Your Ref: OWPC13665
Our Ref: EP/42/17/PL 10-03-2017
Please ask for:
Mrs A Gardner

Alterations to existing public conveniences including provision of disabled facilities & ramped access to toilet.

Public Conveniences Sea Road East Preston

Site Block Plan (1:500)

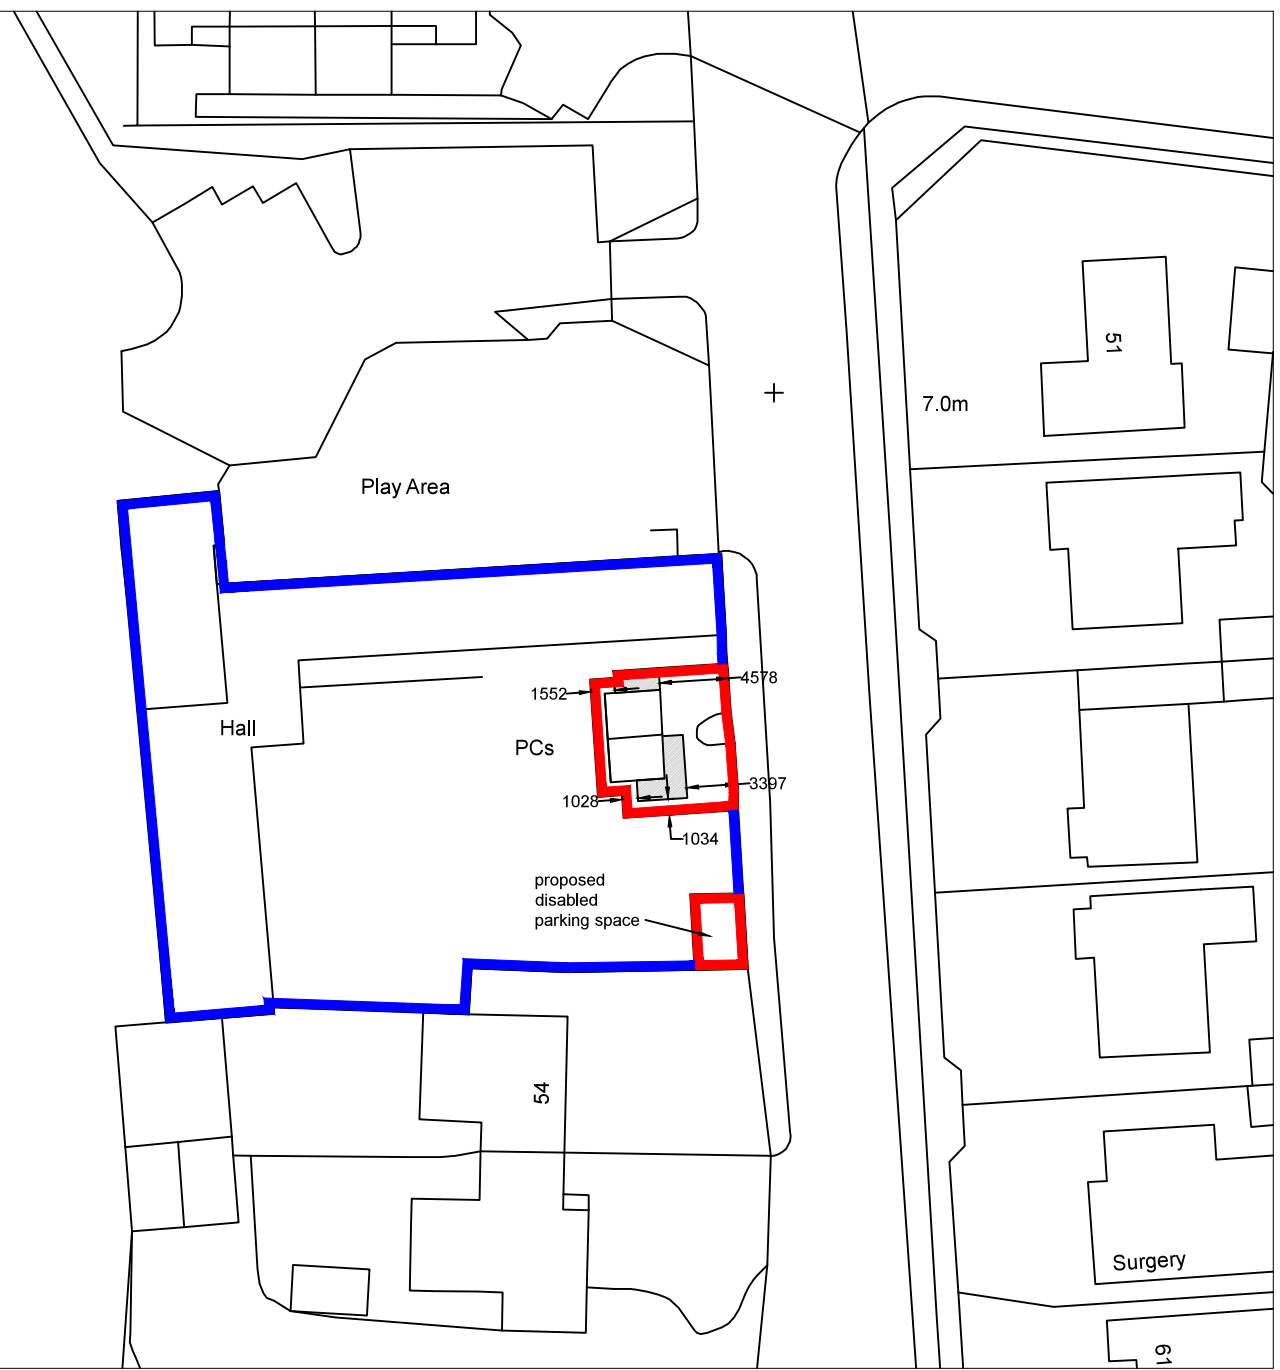
We welcome the proposal to construct a disabled toilet in the existing building. However, we object to the proposal to fell the adjoining fig tree. The expert's report does not recommend felling this tree, which is a much valued element in the street scene. The Tree Report merely recommends that the condition of the trunk should be monitored: this advice should be followed. The tree should not be felled.
